# CITY OF ALBUQUERQUE

June 14, 2019

RE: **7901 Las Lomas NE**  
**Grading Plan Stamp Date: 6/6/19**  
**Drainage File: D16D002I**

Based on the submittal received on 6/6/19, the grading plan cannot be approved until the following corrections are made:

ROCK PLATING DETAIL
NTS

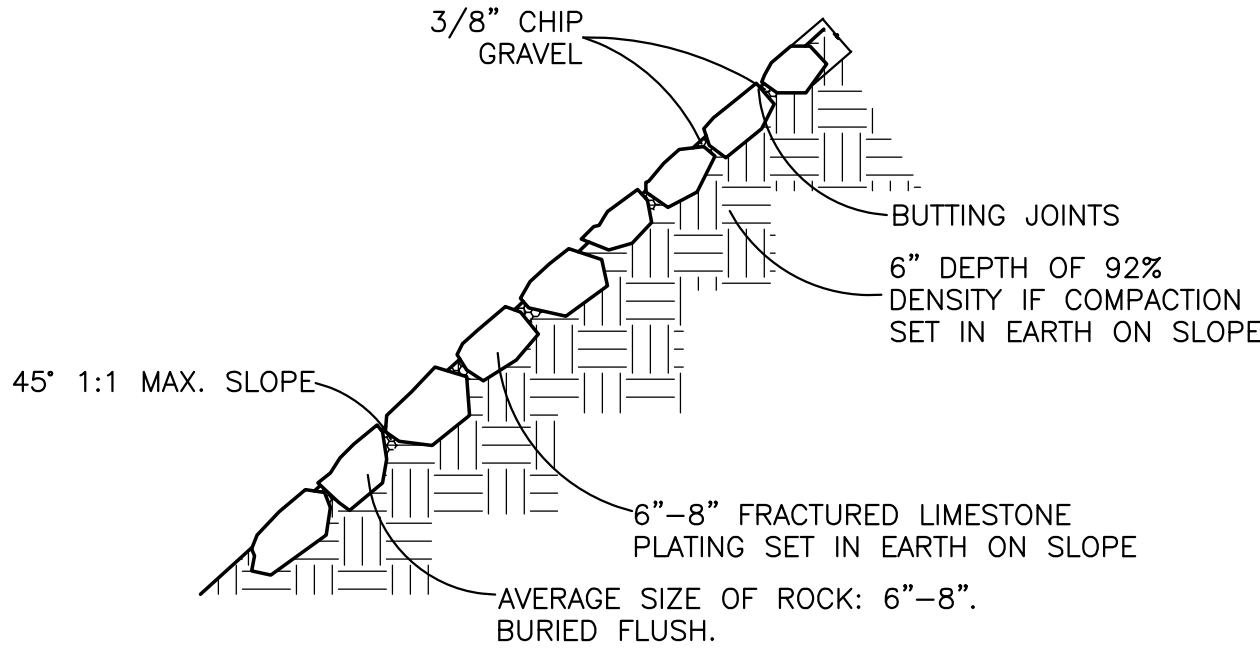
5. Is the rock plating detail for the steep west and south slope? If so, it should be called out.

ENGINEER'S SEAL	7901 LAS LOMAS	DRAWN BY WCWJ
	GRADING AND DRAINAGE PLAN	DATE 6-05-19
7/29/19	 Rio Grande Engineering 1606 CENTRAL AVENUE SE SUITE 201 ALBUQUERQUE, NM 87106 (505) 872-0999	2108048-LAYOUT-6-05-19
DAVID SOULE P.E. #14522		SHEET # —
		JOB # 2109049

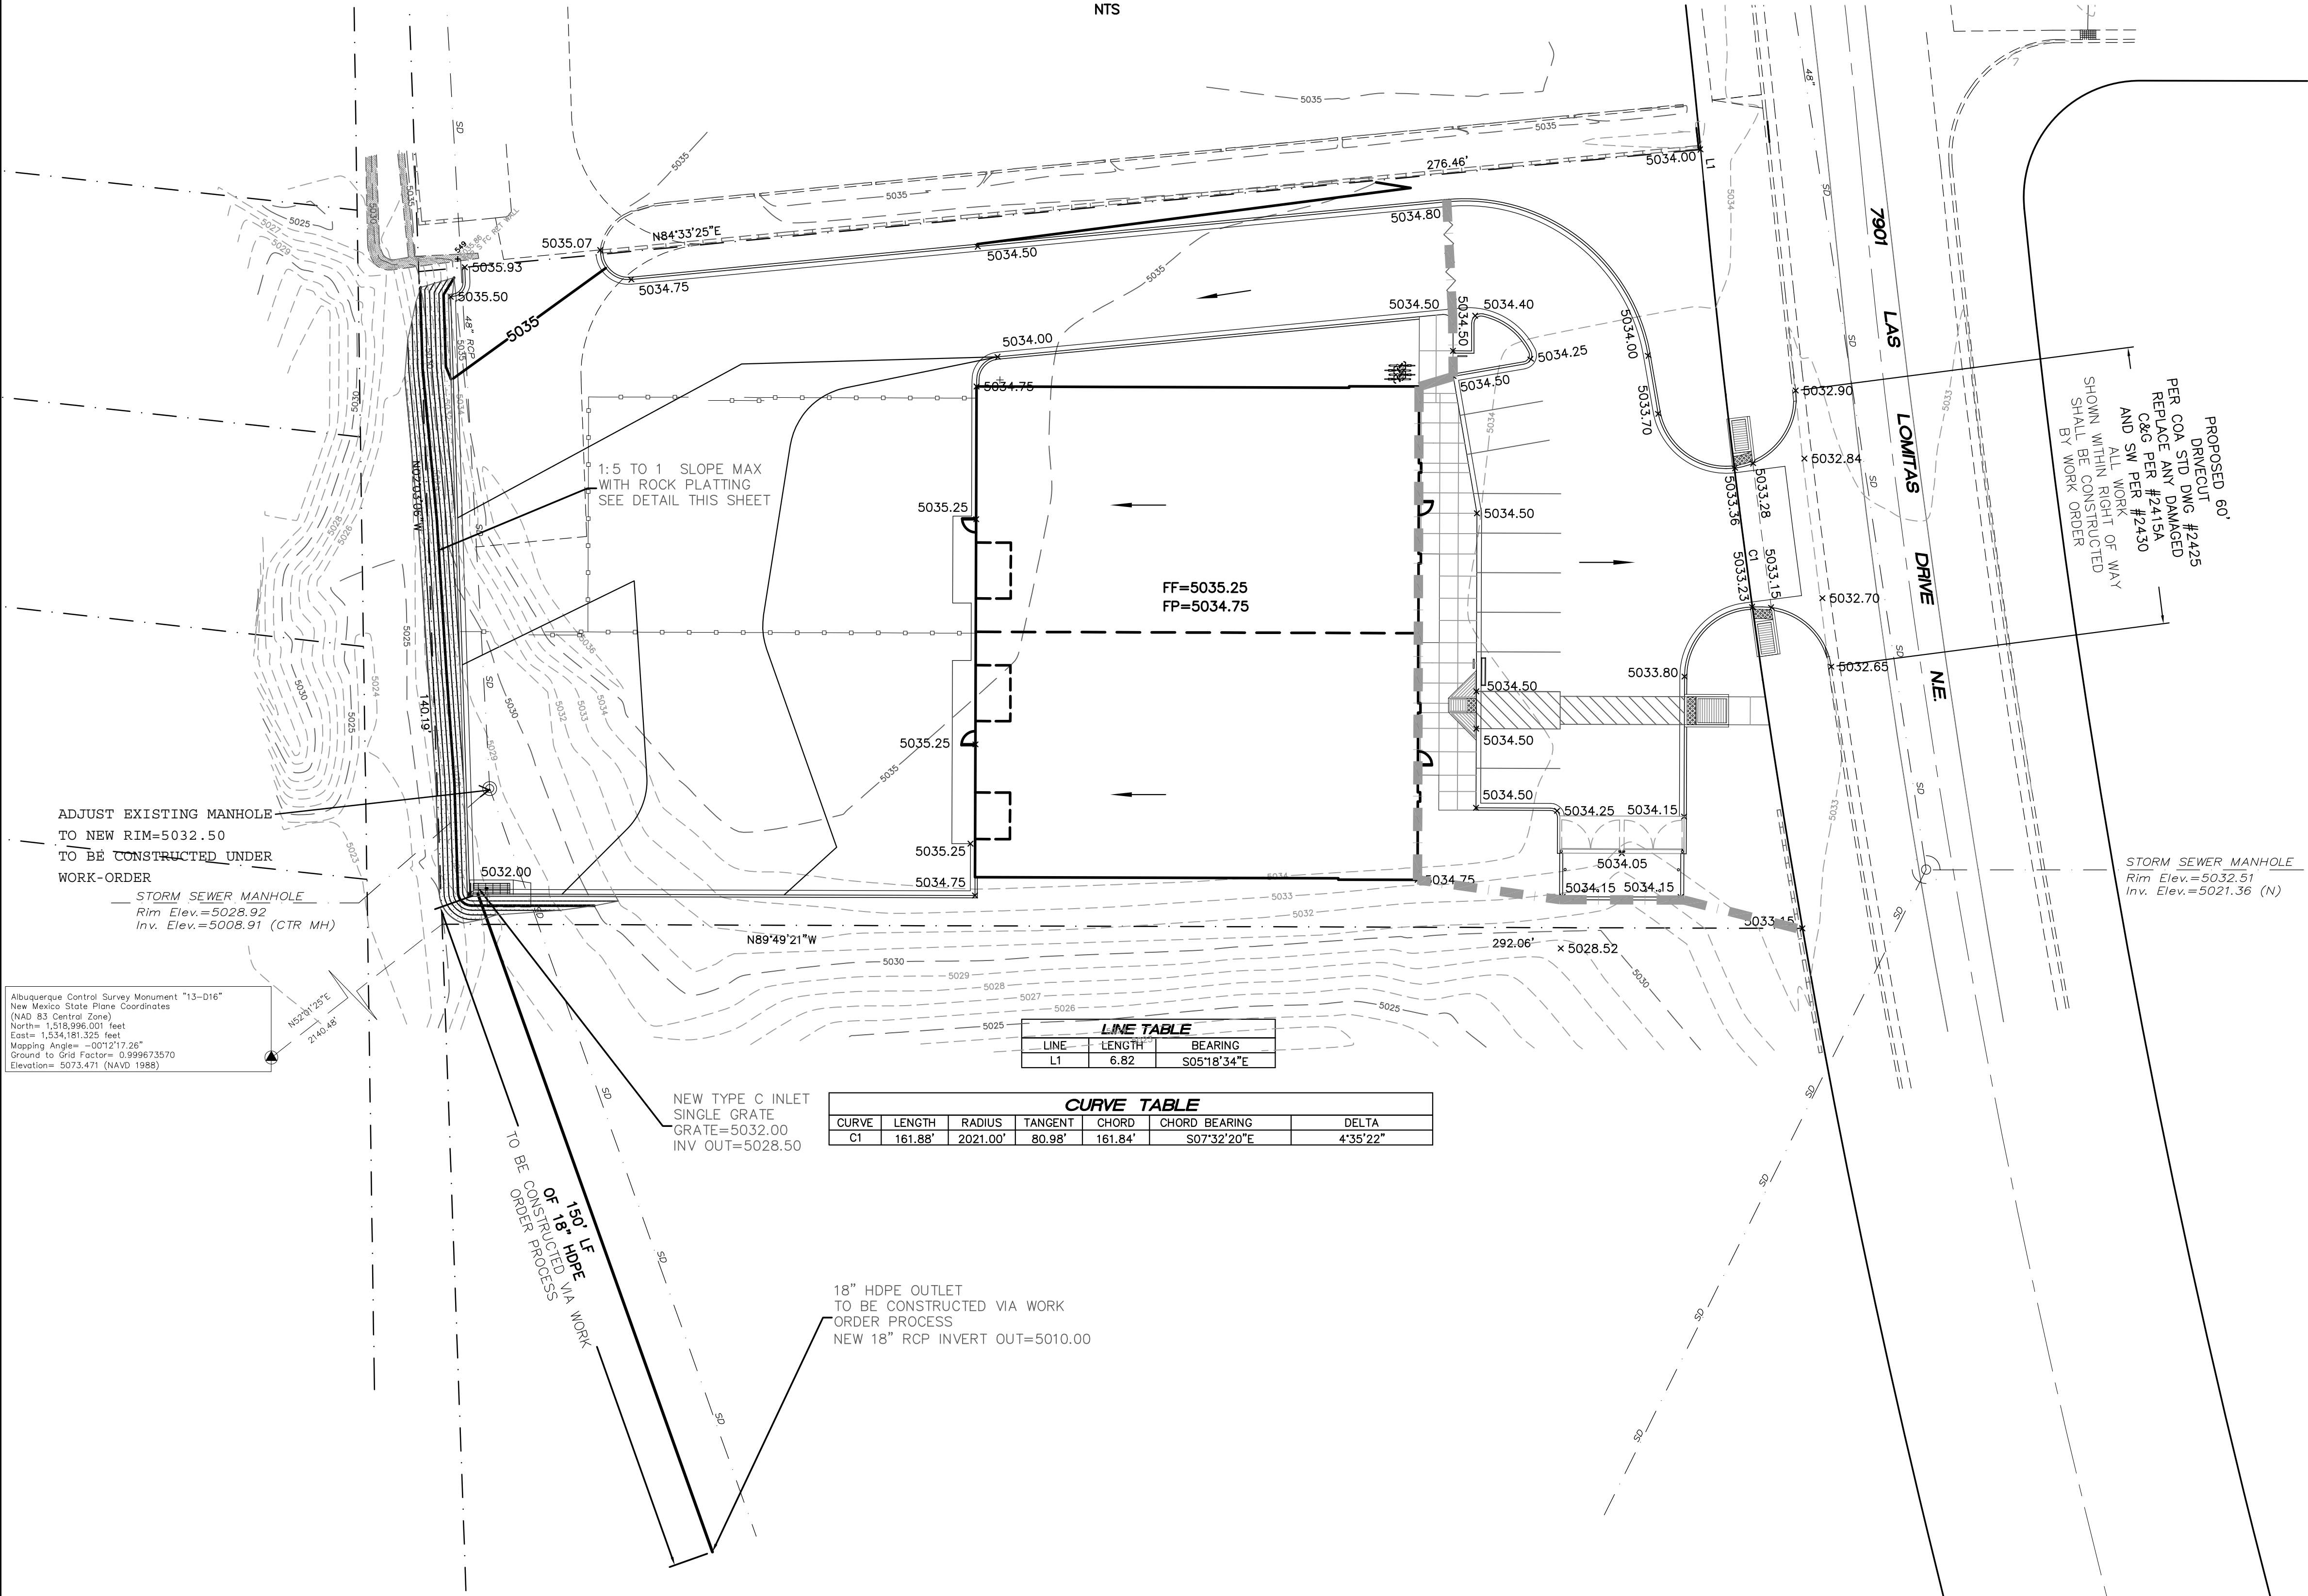
1. This lot got re-subdivided since the master plan and is now a 1-acre lot (43577.65SF). Hydrology, allowable discharge rate, SWQV, Hydraulics, etc.... all will all need to be updated and a revised plan submitted.

3. Legal description is incorrect.

4. The Master Plan shows this property discharging entirely to the street, so the plan to convert the manhole to an inlet and drain west won't be acceptable.
